ASSESSMENT REPORT

Section 75W Modification

Orica Southlands Remediation and Warehouse Development Project – Flood Storage Reconfiguration (MP 06_0191 MOD 1)

Southlands Industrial Estate **22 February 2013** **Figure D11a**
Final Development Scenario 1% AEP flood level difference map

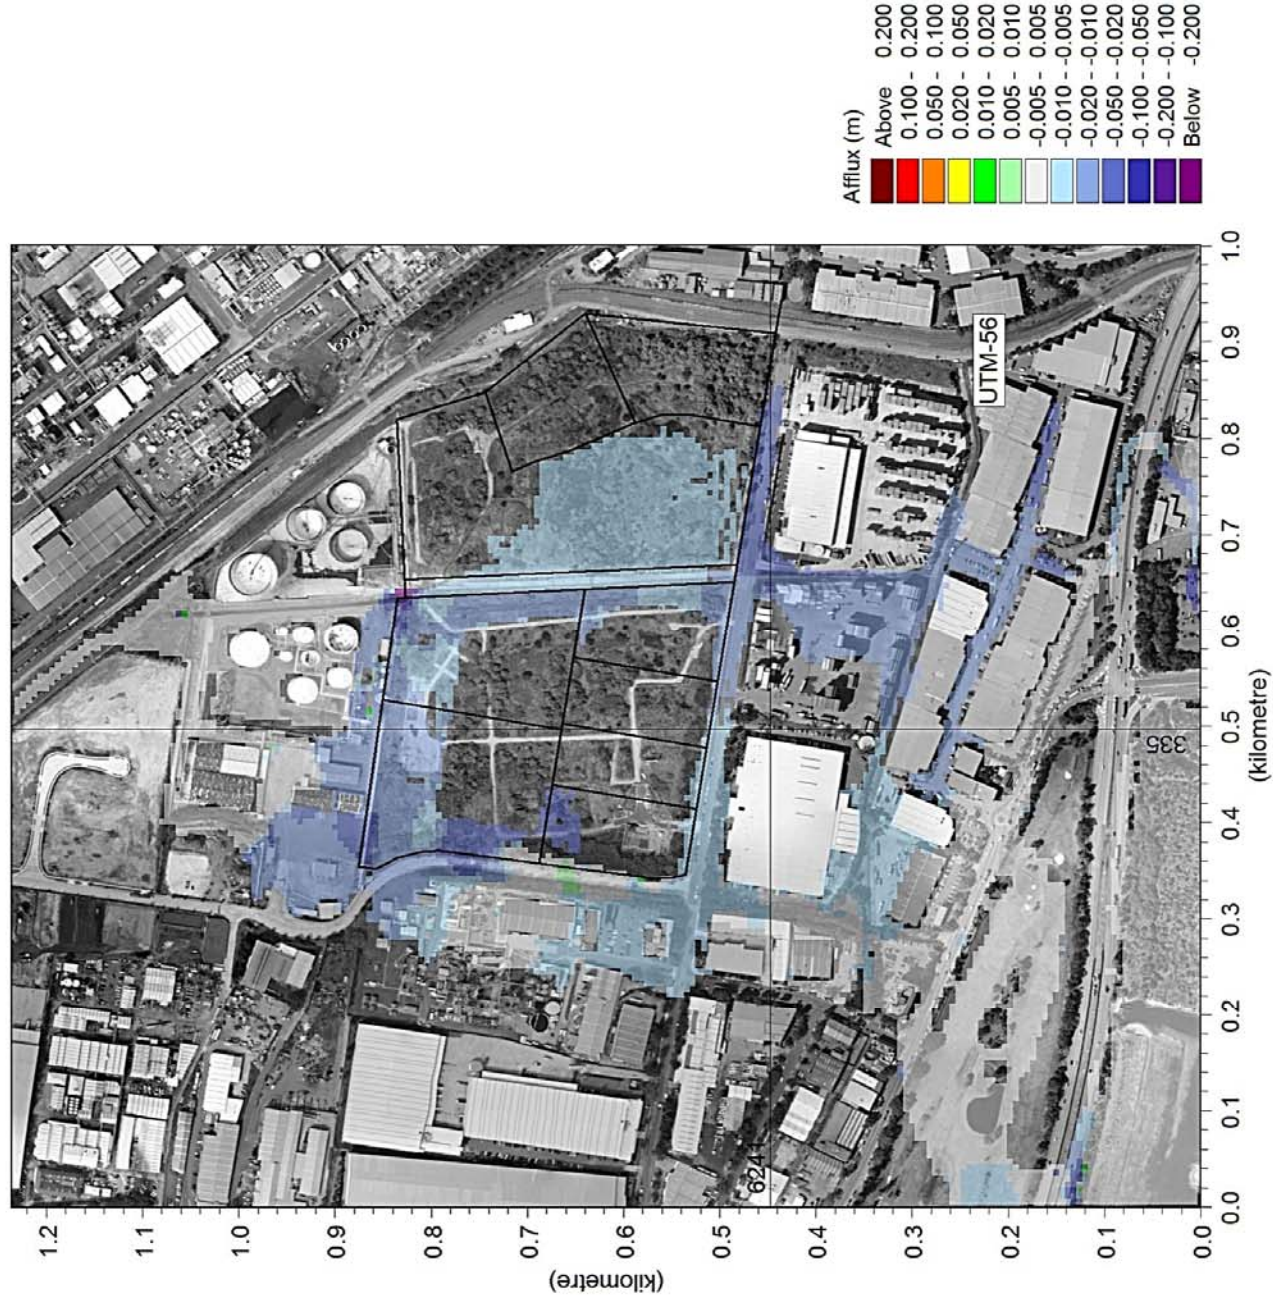
The results of Aurecon's modelling indicate that the revised flood detention basin would still reduce existing peak flood levels on adjoining properties (see **Figure 6**).

SOUTHLANDS FLOODPLAIN MANAGEMENT STRUCTURES
SCALE: 1:500

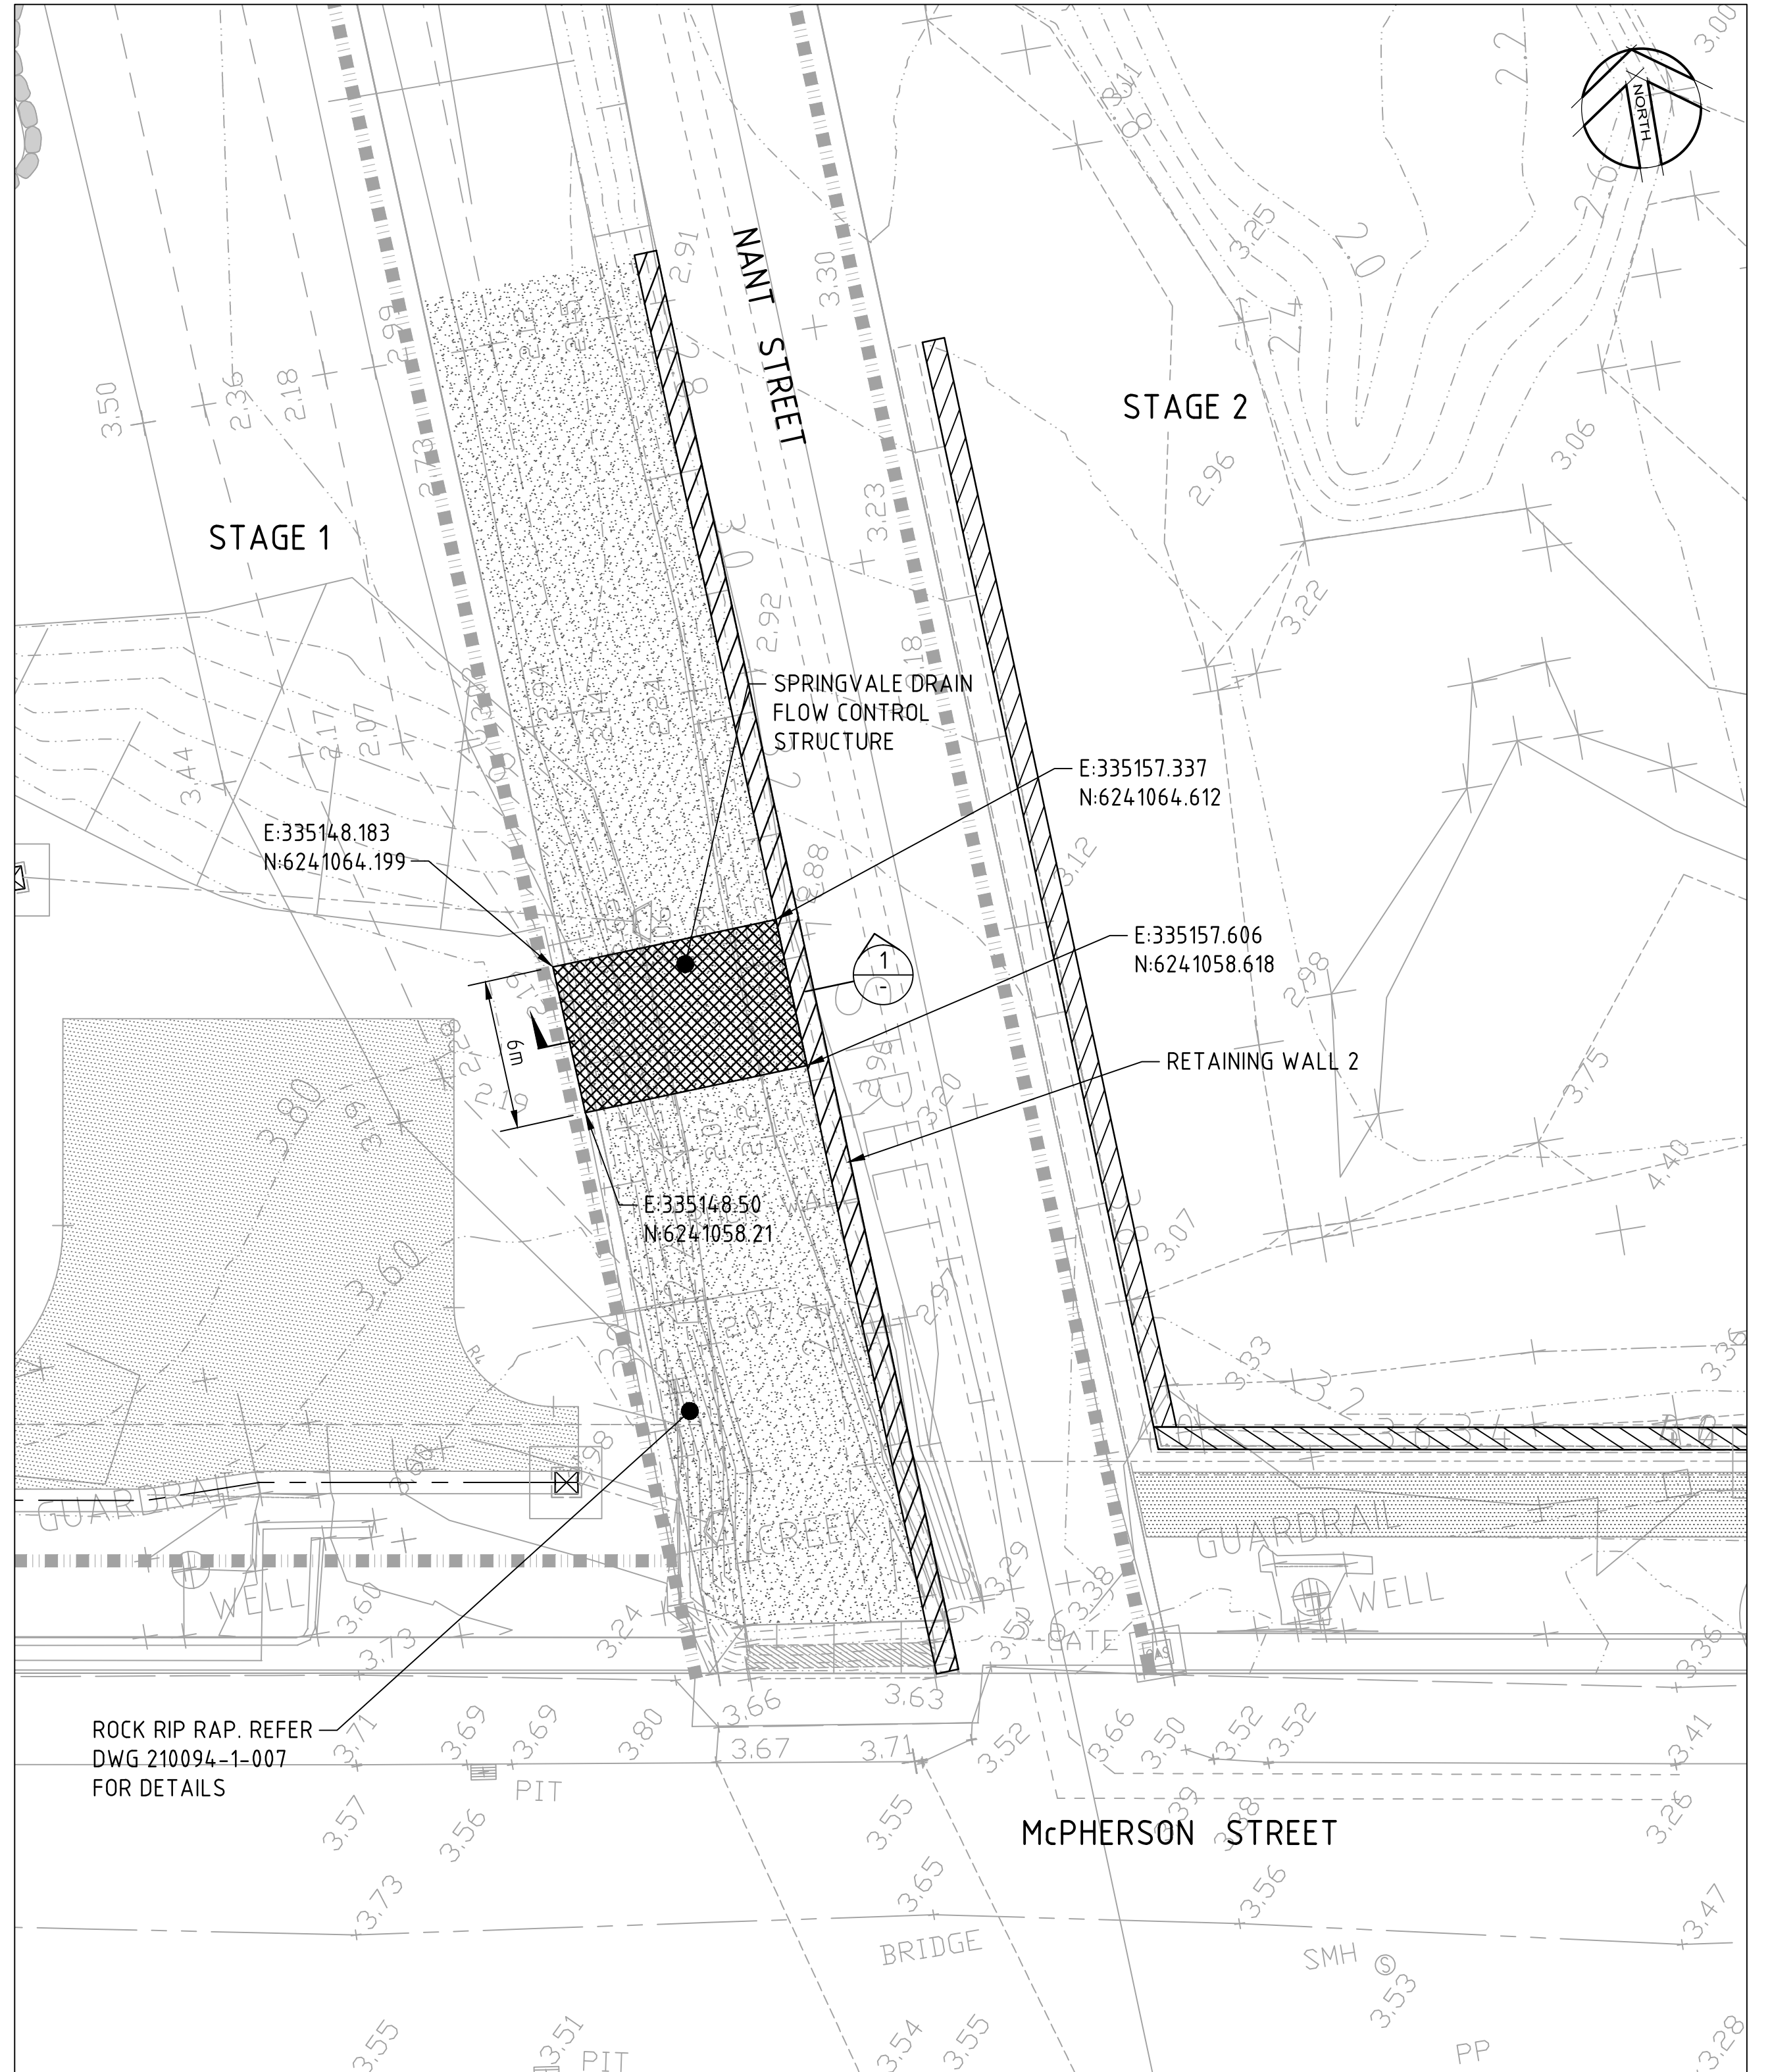
One of the main concerns raised with the revised flood detention basin was the proposed use of a "natural channel constriction" to manage flood waters in lieu of a permanent defined structure. The concern being that the natural channel construction would be more susceptible to erosion or alteration by maintenance activities.

In response to the concerns raised, the Proponent has committed to the installation of a permanent 'defined' control structure (weir / constriction) within Springvale Drain, with details to be shown on submitted plans to the satisfaction of the Department. A condition has been recommended to reflect this commitment.

Southlands Industrial Estate 22 February 2013 **Figure D11a**
Final Development 1% AEP flood level change from approved plans

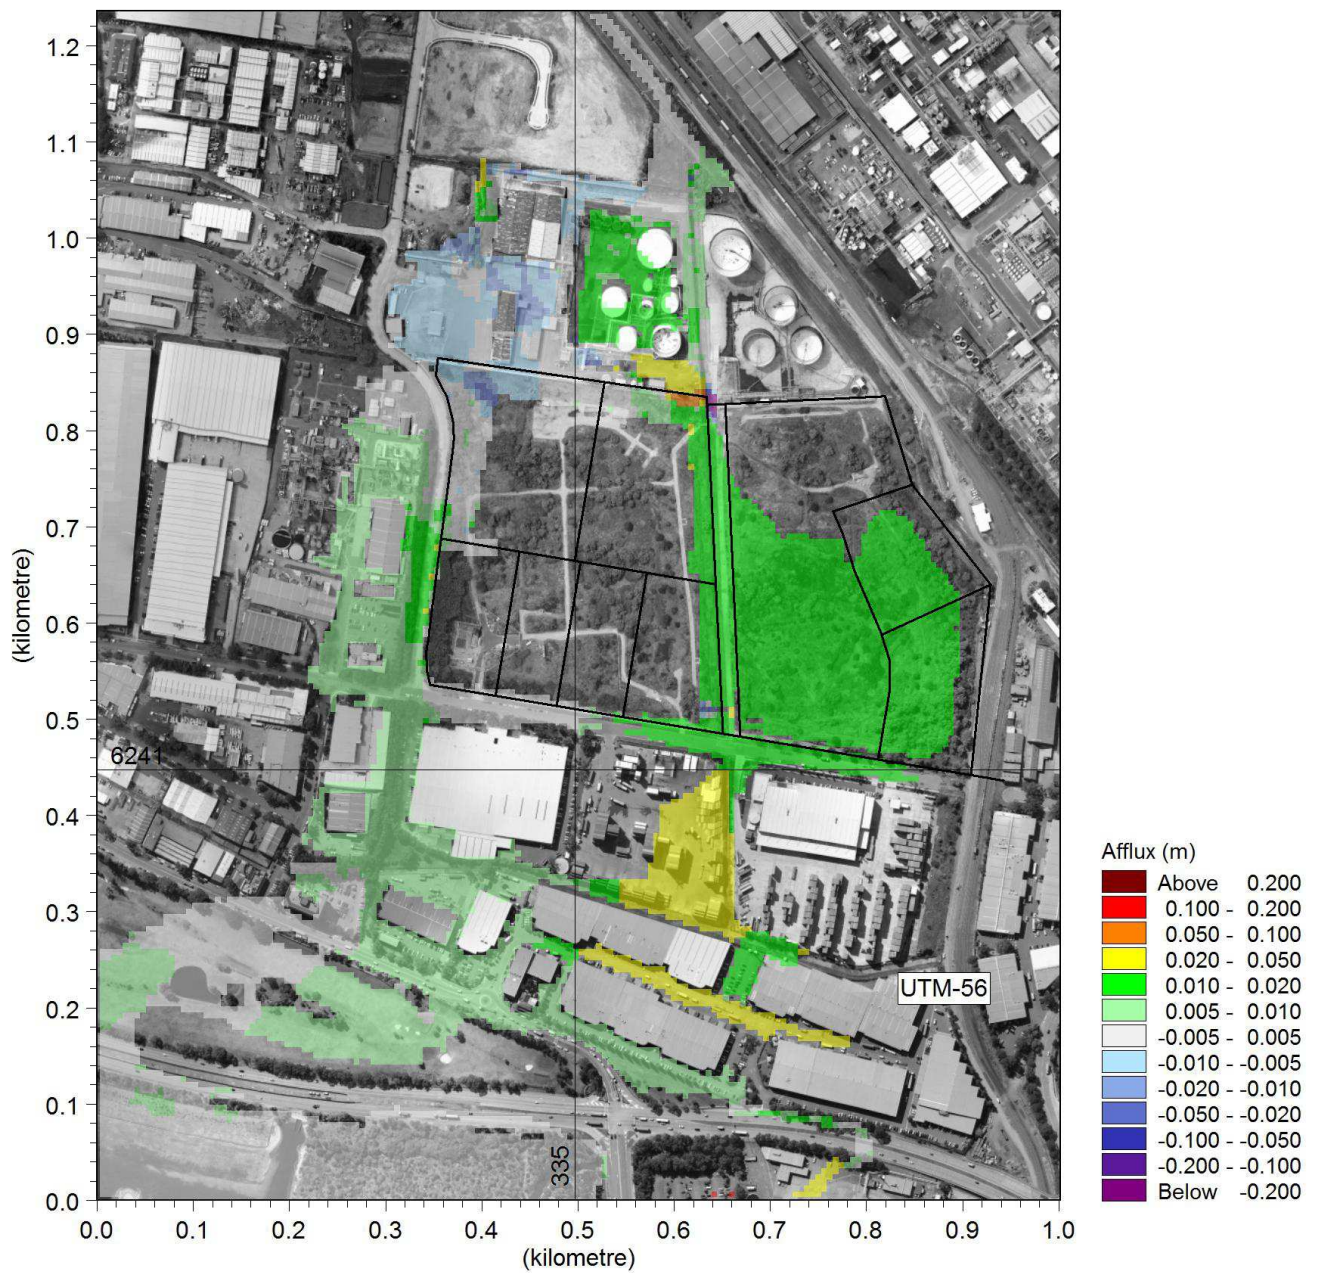
However, the proposed modification would slightly increase the flood levels anticipated by the approved Project's design (see **Figure 7**). For example, the 2010 results indicated a 0.04 reduction in peak level at a certain location and the modified proposal results show only a 0.02 reduction at this location. This means that the peak levels have increased compared to the 2010 results but the design level is still below the existing or pre development level.

Concerns were raised by a public submission over the modelled increase in flood impacts over the original Aurecon modelling (done as part of the Project Application). However according to the Department's expert, the change in flood levels is still satisfactory as the modification would still achieve a reduction in existing flood levels (as shown in **Figure 6**).
